New single garage at front of dwelling and conversion of existing garage to habitable accommodation.

67 Golden Avenue East Preston

Thank you for your internet representation made on 30th April 2012 which has been recorded as an **objection** with the comments as follows:

PROPOSED FRONT (WEST) ELEVATION SCALE 1:100

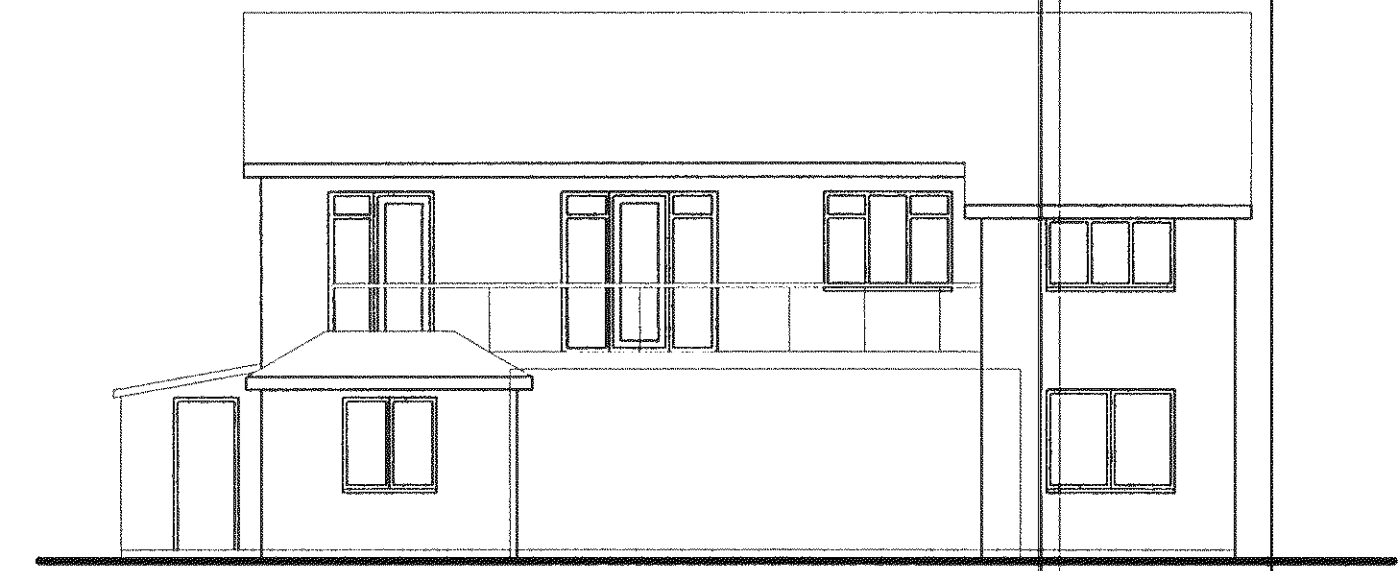
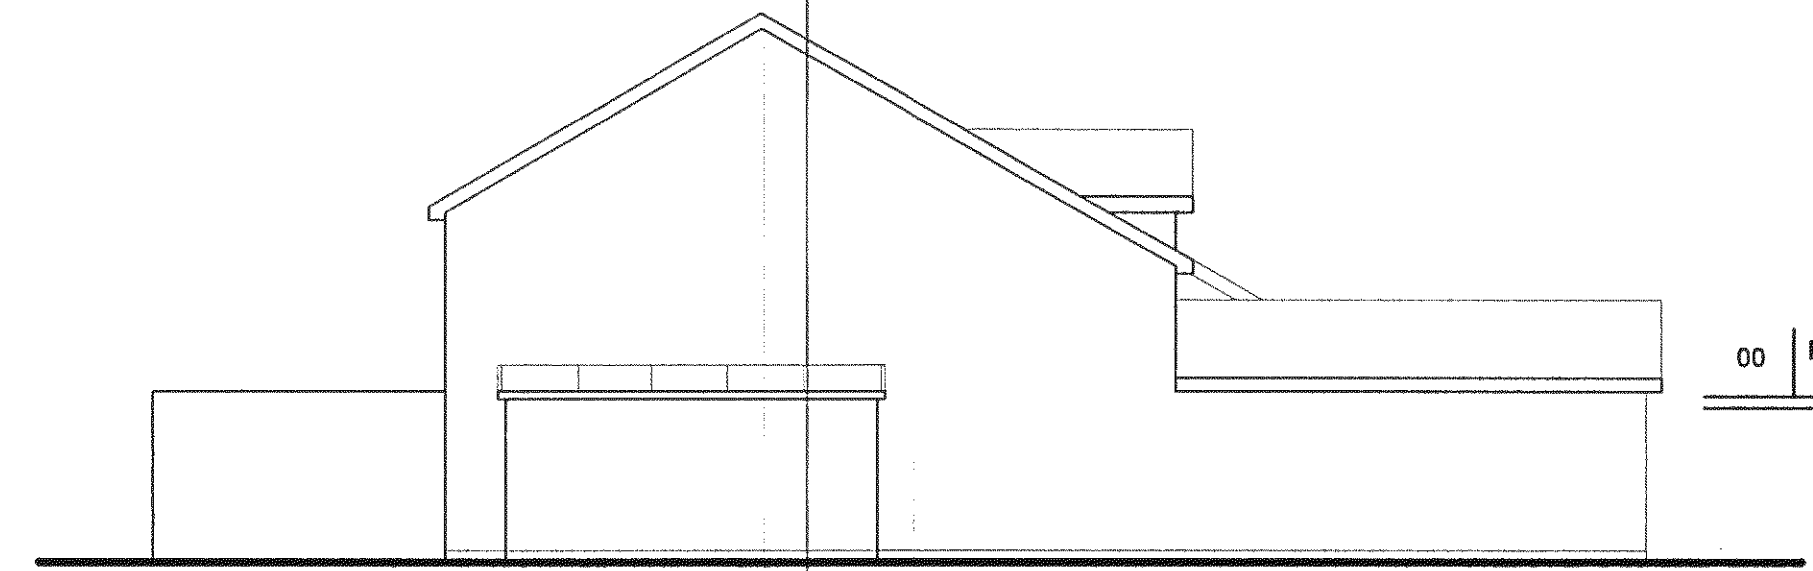
We consider that the addition of a second extension at the front of the house, matching the existing extension that contains the garage, would produce an unattractive appearance. The new extension would look very much an afterthought, and would not be integrated with the design of the house. It is particularly undesirable that the appearance of the house from the road should be harmed by this extension. A much more satisfactory solution would be to provide extra accommodation in an extension at the rear of the building, where it would not affect the appearance of the house from the road. □
